Addendum 01

Date: November 12, 2010

To: Wright Ryan Construction (Construction Manager)
From: Ben Walter, CWS Architects
Regarding: **Oak Street Apartments** – Portland, Maine
Subject: **Addendum 01**

THRESHOLD AT UNIT ENTRANCE DOOR

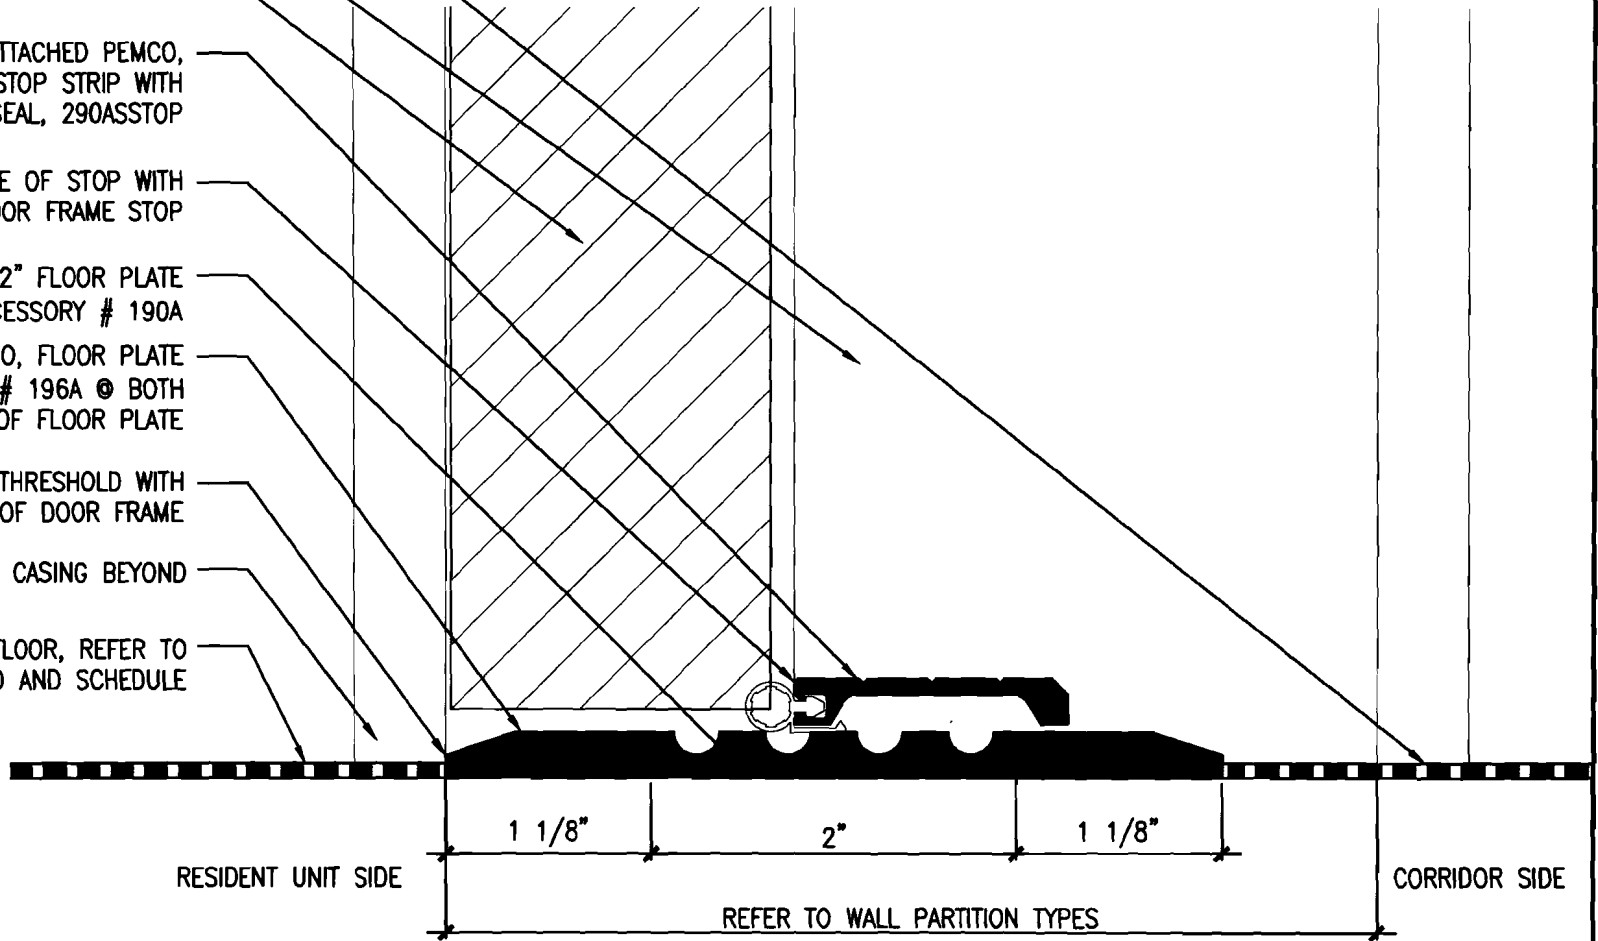
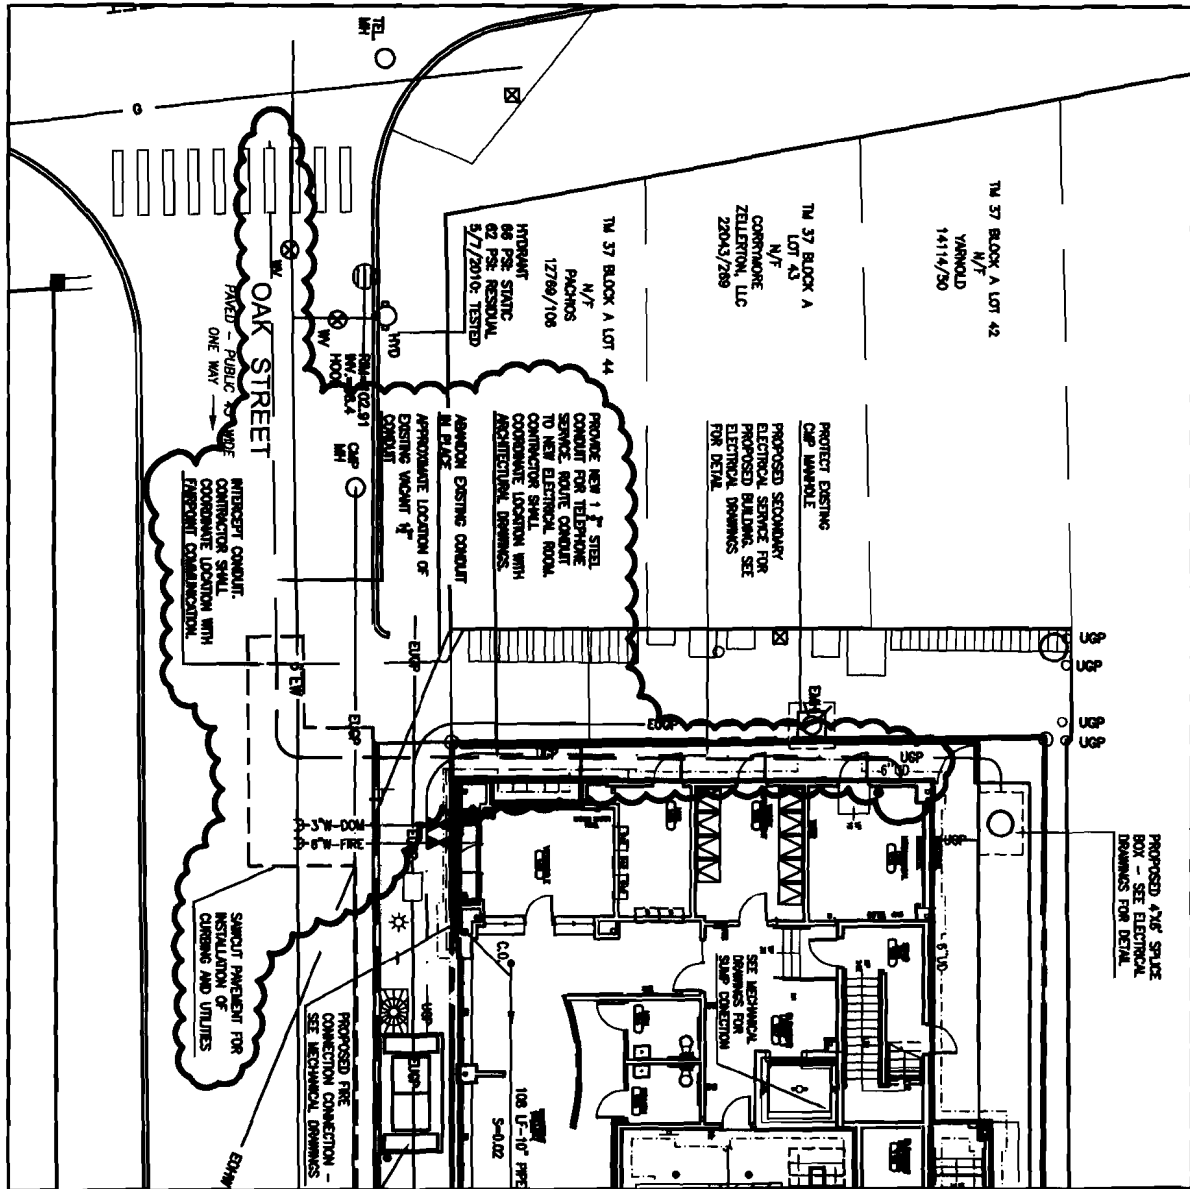
18. Provide a Threshold and Sweep as per attached SKA-1 at all unit entry doors denoted as door number 01 Apartment Entrance at both the IBC Type "A" and Type "B" units. This detail correlates with Threshold 2 listed on 08 70 00 DOOR HARDWARE SCHEDULE.
